Planning Application No: 3/2026/0560

Proposal: Proposed new ground floor shop frontage and change of use of first floor to holiday let.

Location: 15 Moor Lane Clitheroe BB7 1BE

Drawing Title
Proposed Floor Plans and Elevation

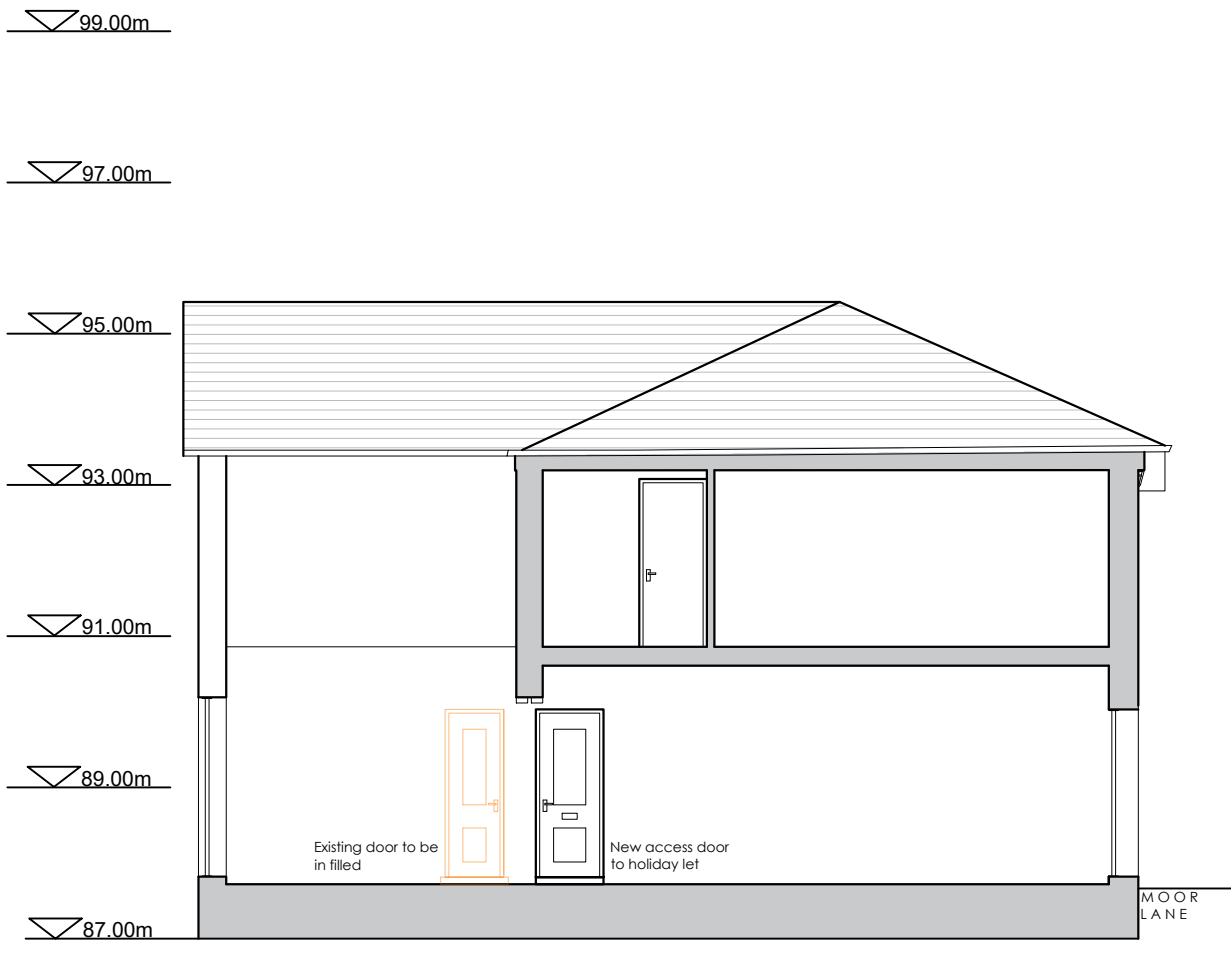
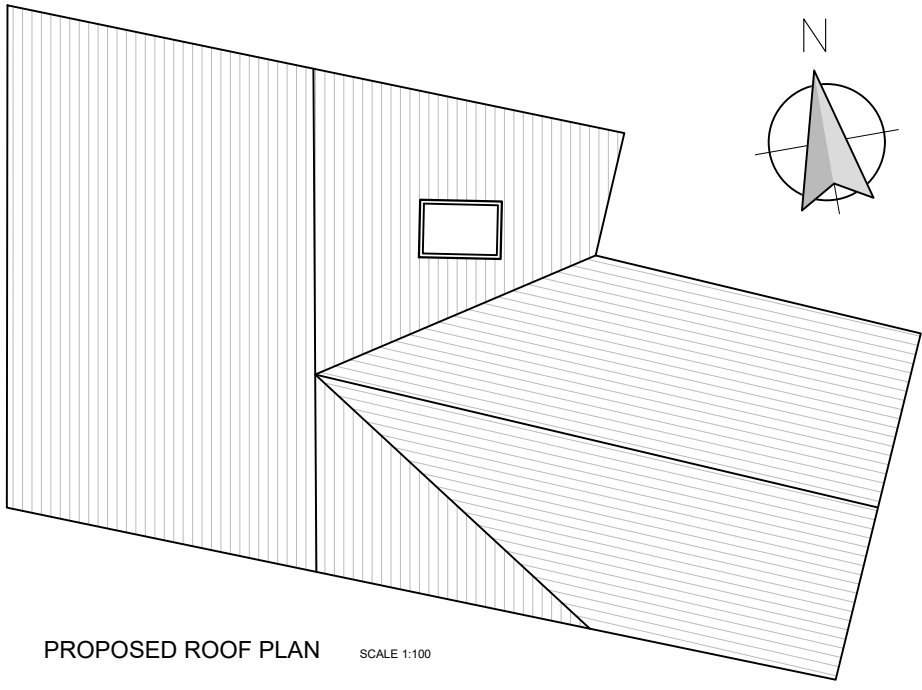
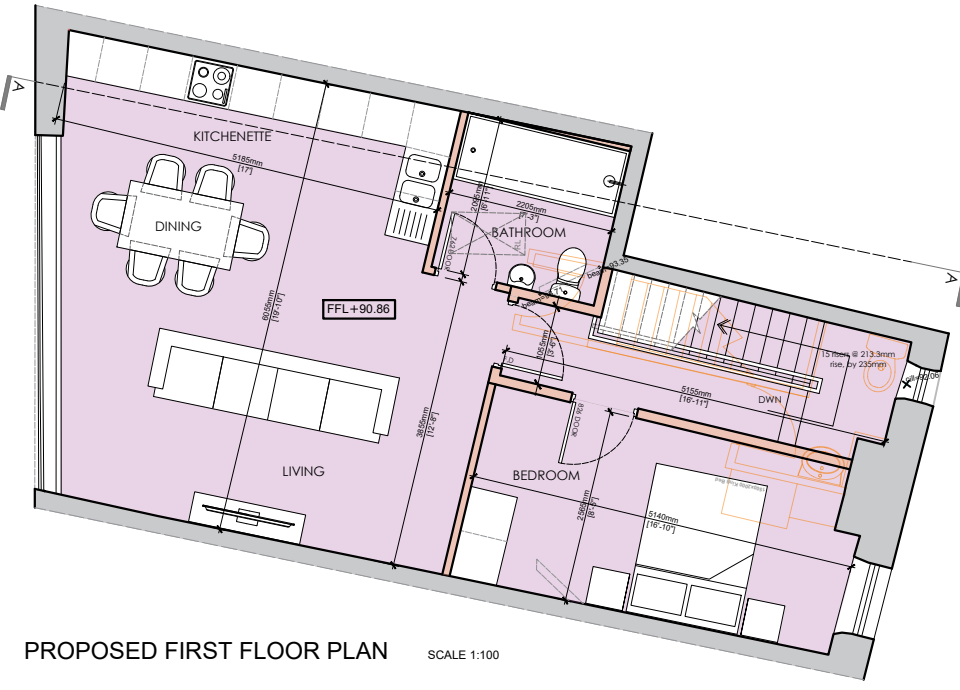
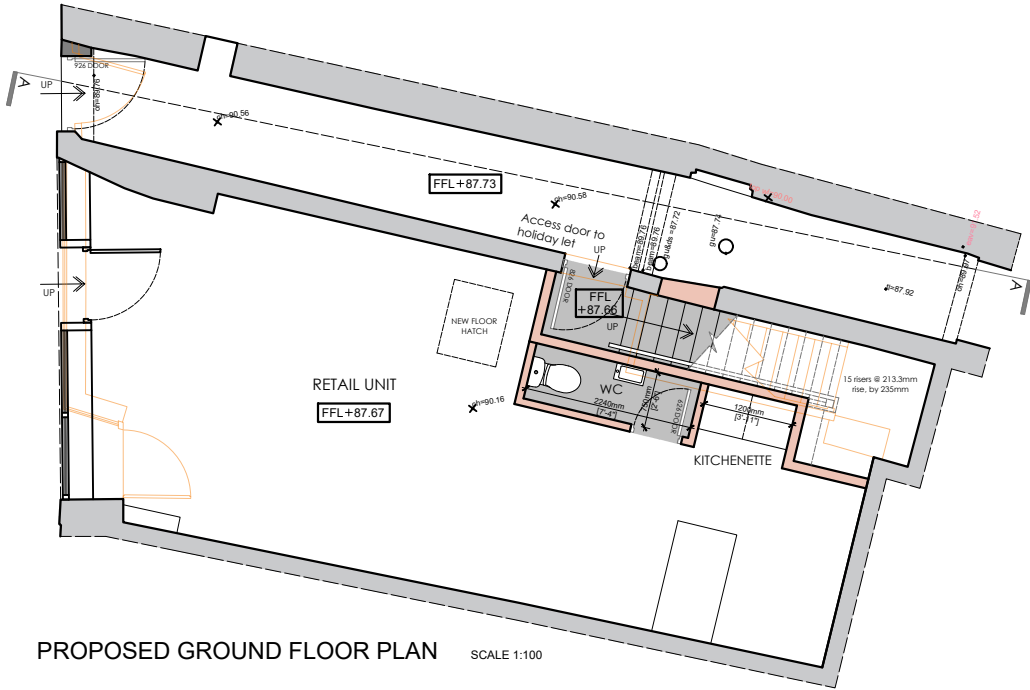
A degree of space should be retained as part of the proposal to allow for the storage of refuse bins, whilst retaining pedestrian access. As a result, this should avoid refuse migrating and ultimately being left on the adopted street.

As a new shop front is proposed, the informative note below is recommended.

- A degree of yard space should be retained as part of the proposal. This should be adequate to allow for the storage of refuse bins, whilst still maintaining limited pedestrian access. As a result, the retained area should avoid refuse migrating and ultimately being left on the back street.

- The developer should be aware that any works on, or immediately adjacent to the adopted highway network, would require the appropriate permits from Lancashire County Council's Highways Regulation Team, who would need a minimum of 12 weeks' notice to arrange the necessary permits. They can be contacted on lhsstreetworks@lancashire.gov.uk or on 01772 533433.
